20 August 2025

Proposal: **Construction and operation of a new special education school catering for 200 students in Years K-12 including 2 lot subdivision and ancillary civil works.**
Property: **84 Gavenlock Road, Mardi**
Application: **SSD-67173718**

I refer to your letter for Council to review and provide an online submission regarding the proposed Construction and operation of a new special education school catering for 200 students in Years K-12 including 2 lot subdivision and ancillary civil works. Council provides the following in relation to the provided development on the subject development site:

01 Section 01
1:200

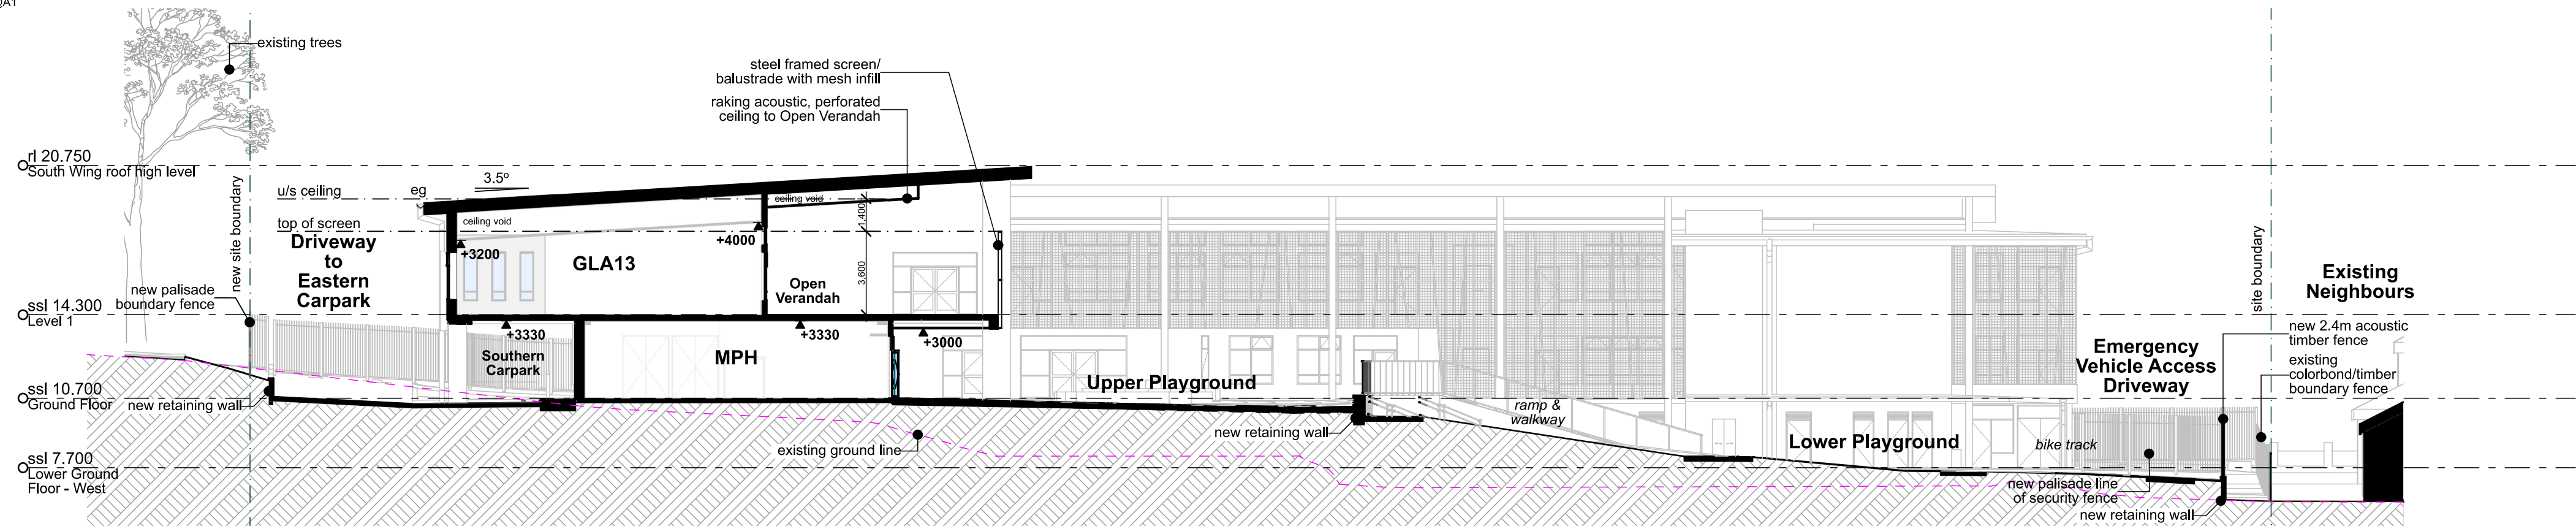
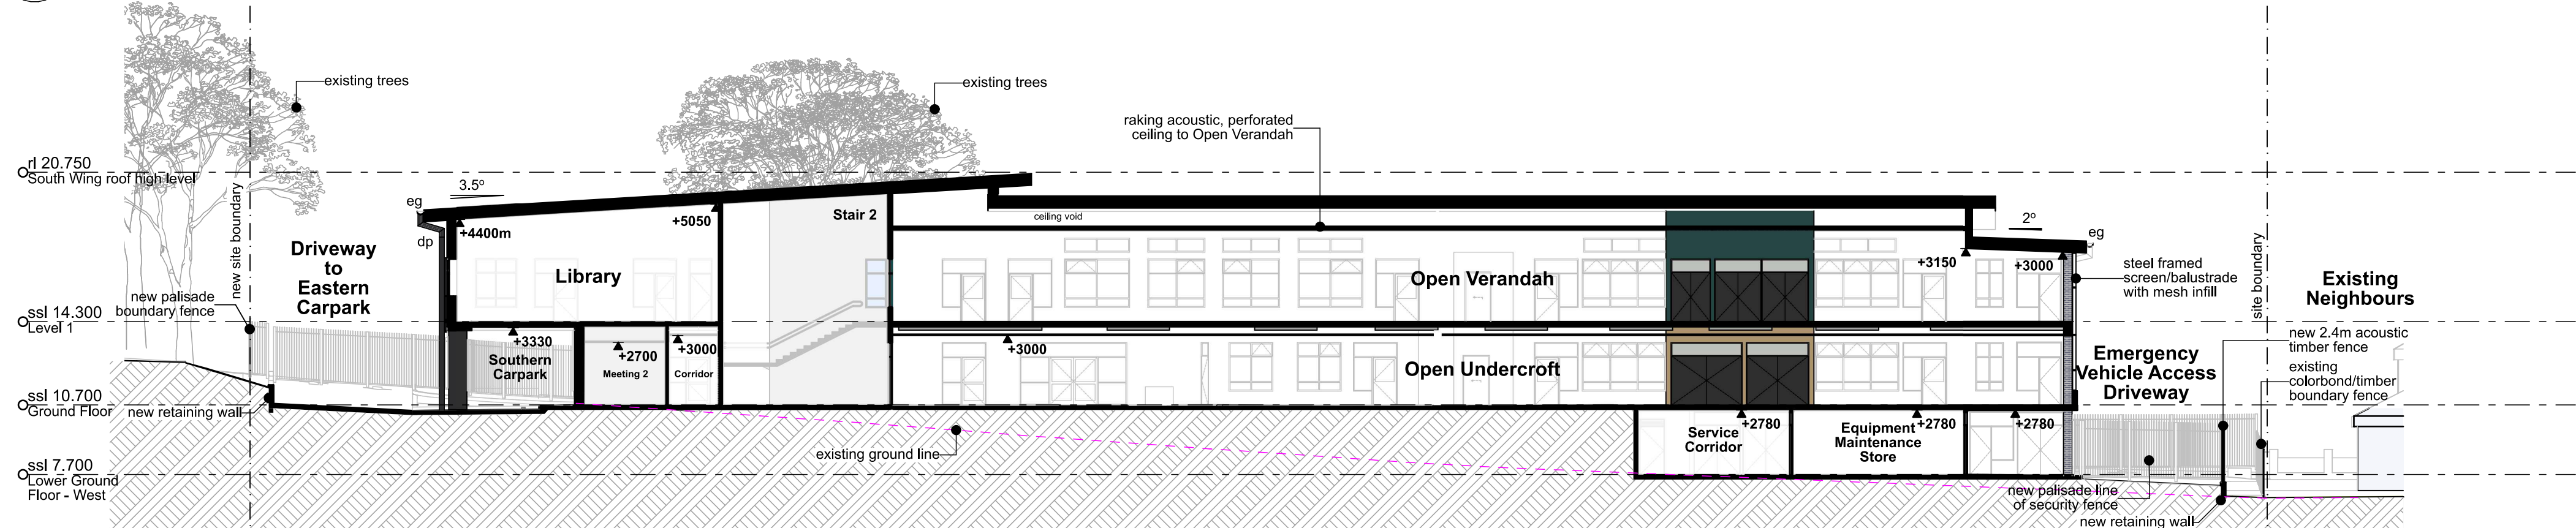
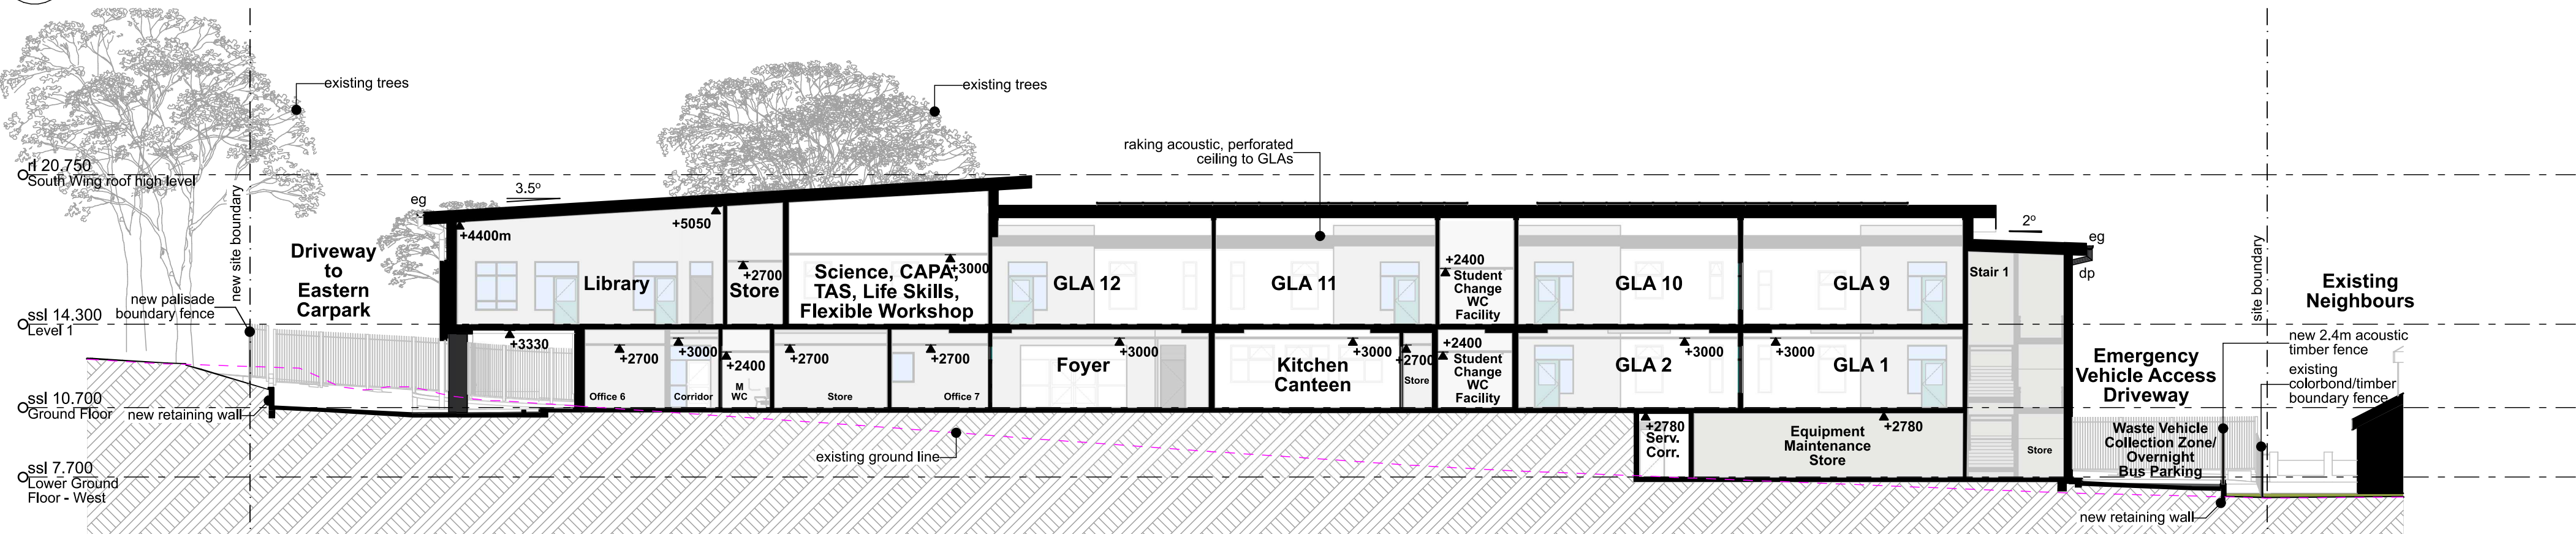
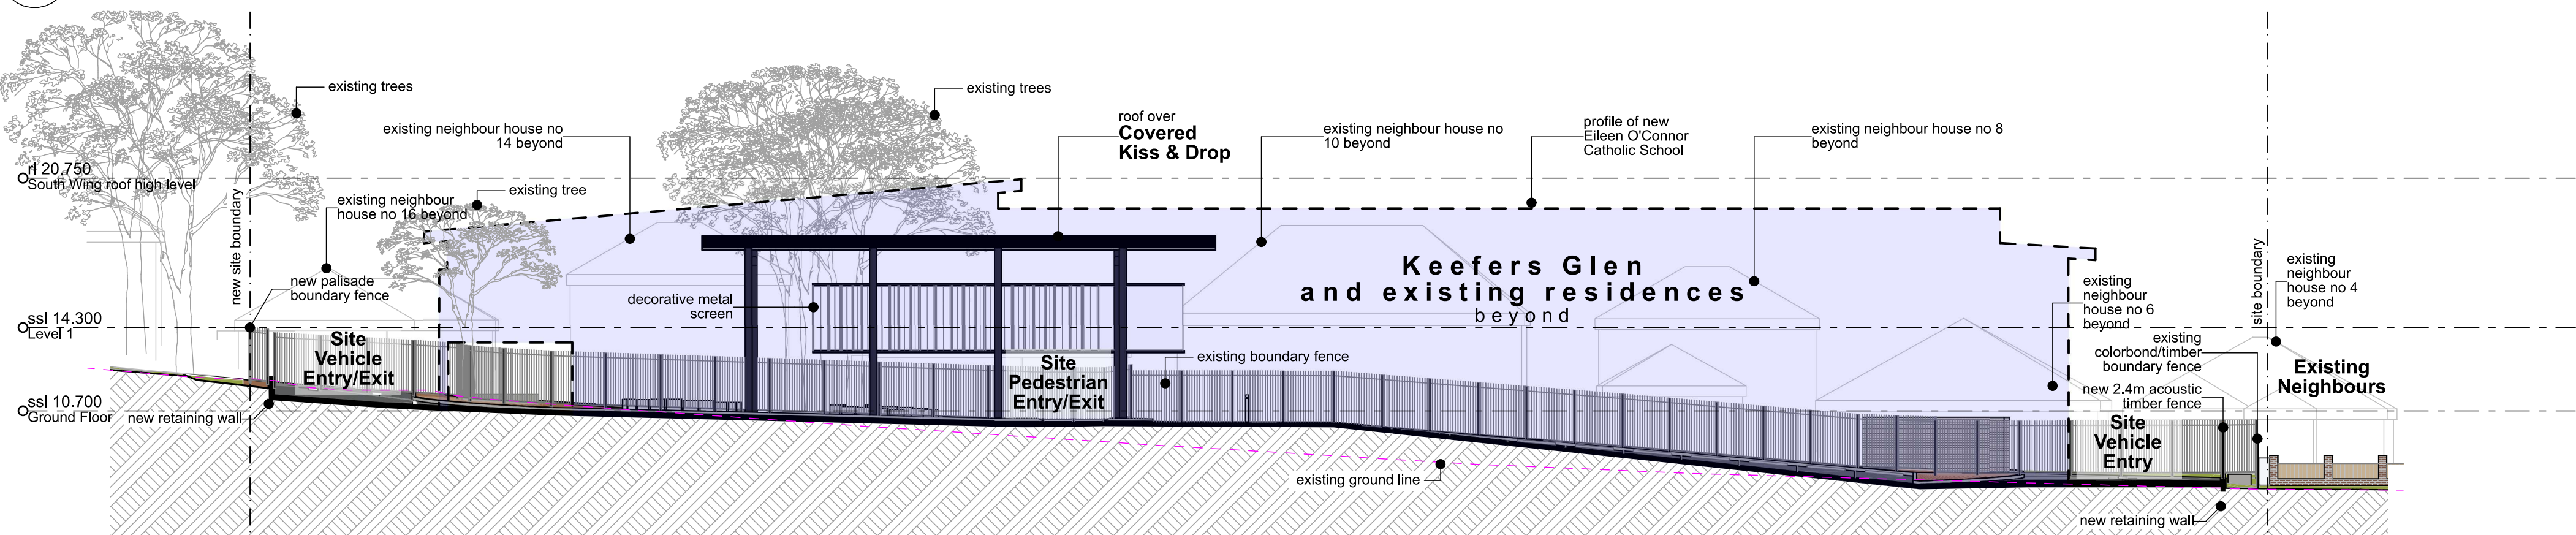
- The 3-storey building appears imposing to the street and does not relate to the low-scale residential development in the street.
- The vertical stripes in the building visually elongate the development and do nothing to break up the overall bulk and scale of the development.

- The building forms are generally simple rectangular prisms and have little variation to break up the length of buildings. These are particularly visible as the perimeter of the development is generally surrounded by vehicle access driveways without sufficient room for landscaping.

- The internal elevations have first level walkways of 'steel framed screen/ balustrade with mesh infill'. This choice of materials seems quite heavy-handed and could be likened to something used in a correctional facility, or on a bridge to prevent antisocial behaviour.

Could there be consideration of an alternative more friendly solution, for example using colour or more natural looking materials in selected areas.
